From: [REDACTED]
Sent: 04 August 2026 10:02
To: Lottie Hargreaves; Planning
Subject: 3/2026/0490

3/2026/0490 - Proposed extension: 15 Croasdale Drive, Clitheroe BB7 1LQ

Drawing Title
Proposed Plan and Elevations

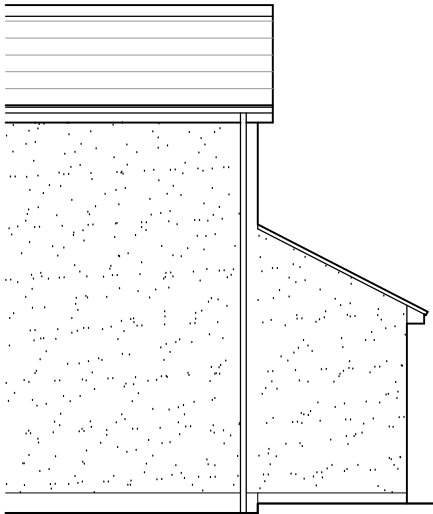
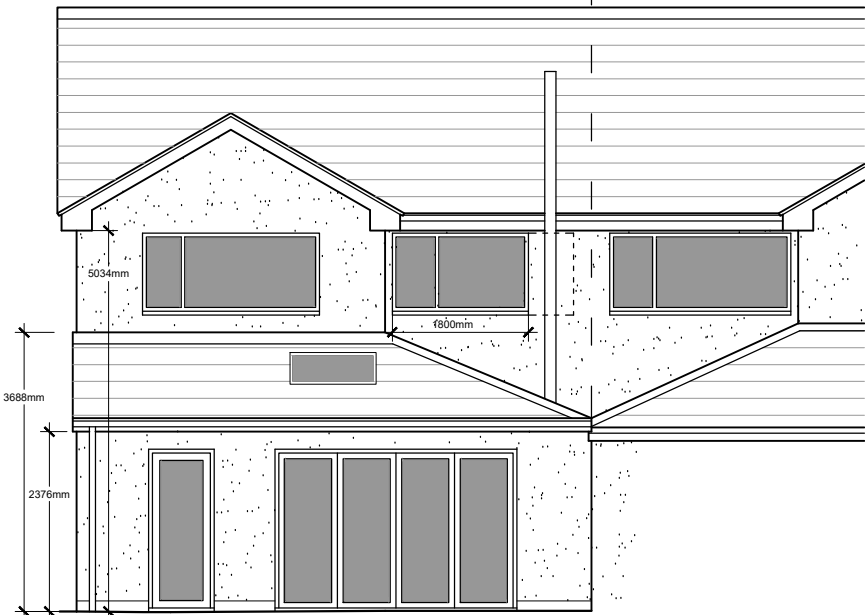
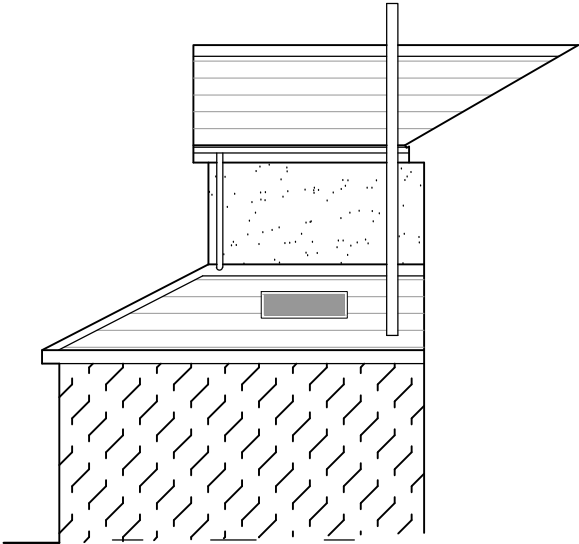
As [REDACTED] we are not in agreement with the proposed position of the stove flue as it is located in very close proximity to [REDACTED], specifically a [REDACTED] and a [REDACTED], both opened regularly for ventilation.

The plans show the flue discharging below the main roof ridge line, in a sheltered space [REDACTED] the [REDACTED], potentially directing smoke and odors [REDACTED] and clean air space, and unfortunately [REDACTED] which would be affected.

Further concern is the impact which smoke exposure could have on the exterior of [REDACTED] and the potential fire risks with the flue being situated [REDACTED] the roof edge and eaves.

As no roof plan is available we are unsure how the proposed north east extension wall may affect [REDACTED] as it is unclear to us from the rear plan.

As per our telephone conversation and email communication, I have emailed you a request for clarification of the type of stove and the proposed north east elevation wall proximity for our further comment.
